KU-RING-GAI COUNCIL

SUBMISSION IN RESPONSE TO ENVIRONMENTAL IMPACT STATEMENT FOR THE NORTH CONNEX TUNNEL PROJECT

9th September 2014

M1-M2-5000-DR-UD-0550
NORTHERN VENTILATION FACILITY - CROSS SECTIONS

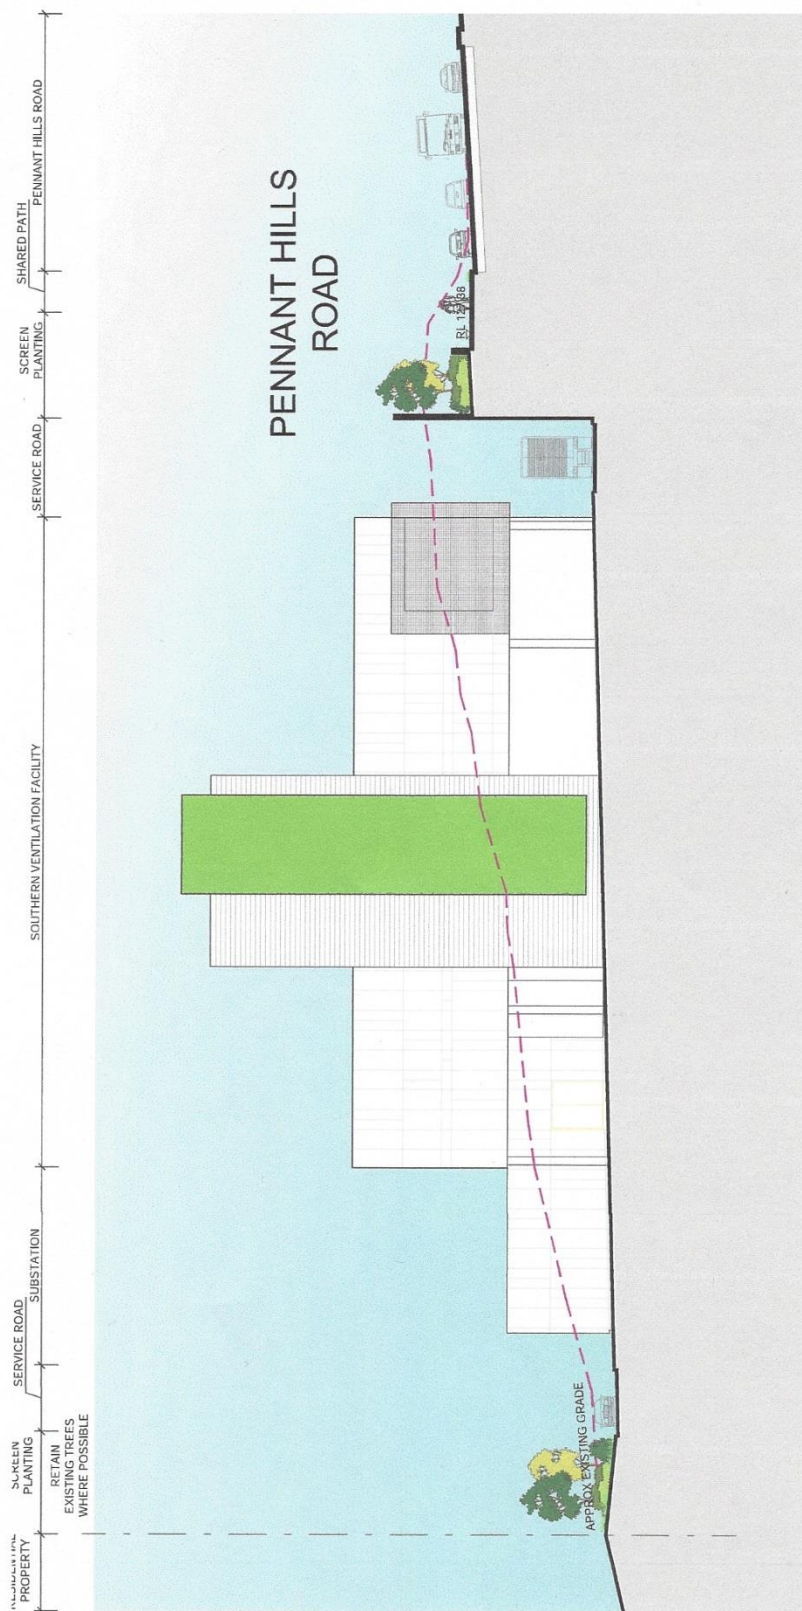
The height of the ventilation stacks, where proposed, is identified as being 15 metres tall. This will have a negative impact on the visual character and Heritage Conservation Area of Wahroonga.

Further information should be provided regarding the northern ventilation facility and tunnel portal jet fans and a review of potential sleep disturbance from the operation of the northern ventilation facility.
